CPP Project 7093

Subject: Wind Engineering – Central Courtyard W1 Darling Drive Student Accommodation North (SSDA12)

Ref: (1) CPP Report '7093 SICEEP W2 Student Accommodation Wind Report\_Final - rev3', dated 5 June 2013.  
(2) ASPECT Studios Drawings "State Significant Development Application (SSDA12) W1 – Darling Drive Student Accommodation North' dated January 2016.

SECTION 2 - EAST / WEST

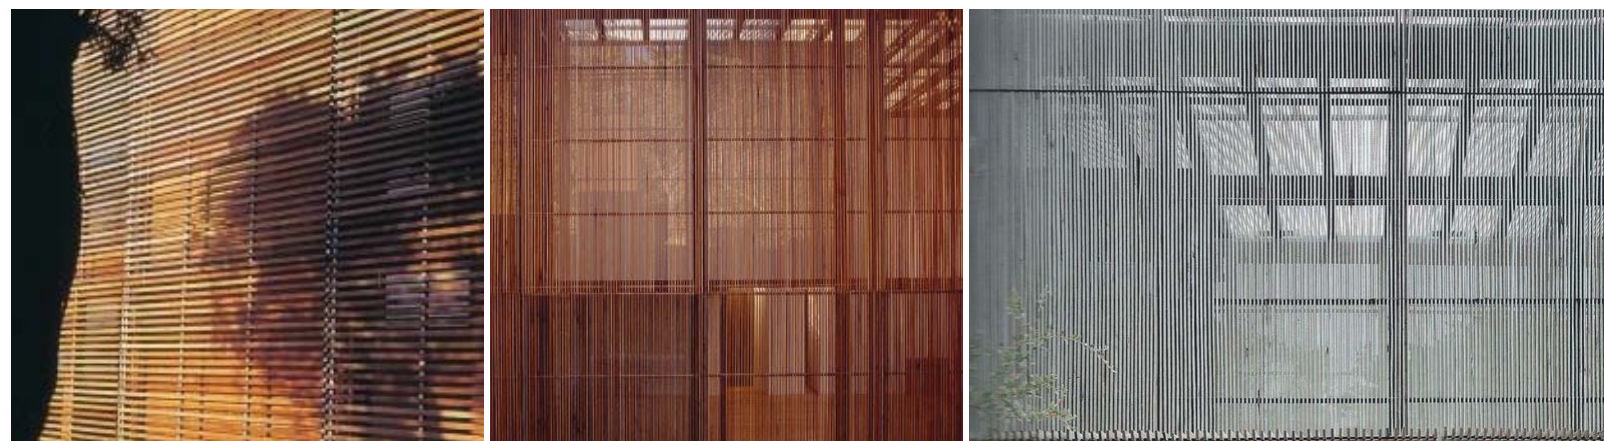
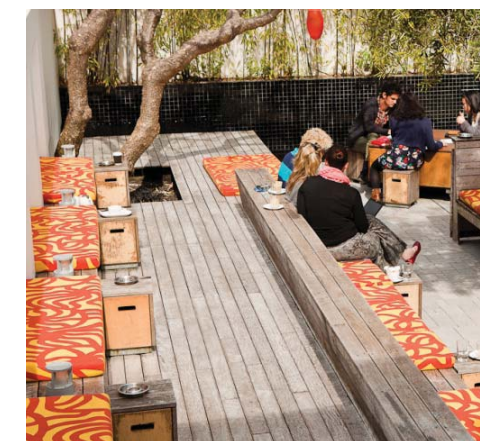
*Further information & justification is required for the proposed use of the central courtyard:*

- Provide confirmation of mitigation measures to address the likely wind impacts on the central courtyard (currently noted as comfortable for 'walking').

CPP provided advice to Aspect Studios as to likely comfort levels to the tiered seating and principles that could be employed to ameliorate potential wind impacts to this area. This has been implemented by modifying the design to incorporate a 1.8 m high solid timber balustrade to upper levels and sides of the amphitheatre (>1 m high) in order to provide some local wind protection to patrons using the amphitheatre. The top 600mm will include 25% porosity to assist disperse stronger flows and provide amelioration. Within the amphitheatre wind conditions will likely be in the range of Pedestrian Standing and Pedestrian Sitting under

Lawson and could be quantified through further numerical simulation or wind tunnel testing. This local wind protection is unlikely to extend far beyond the amphitheatre space enclosed by the screening.
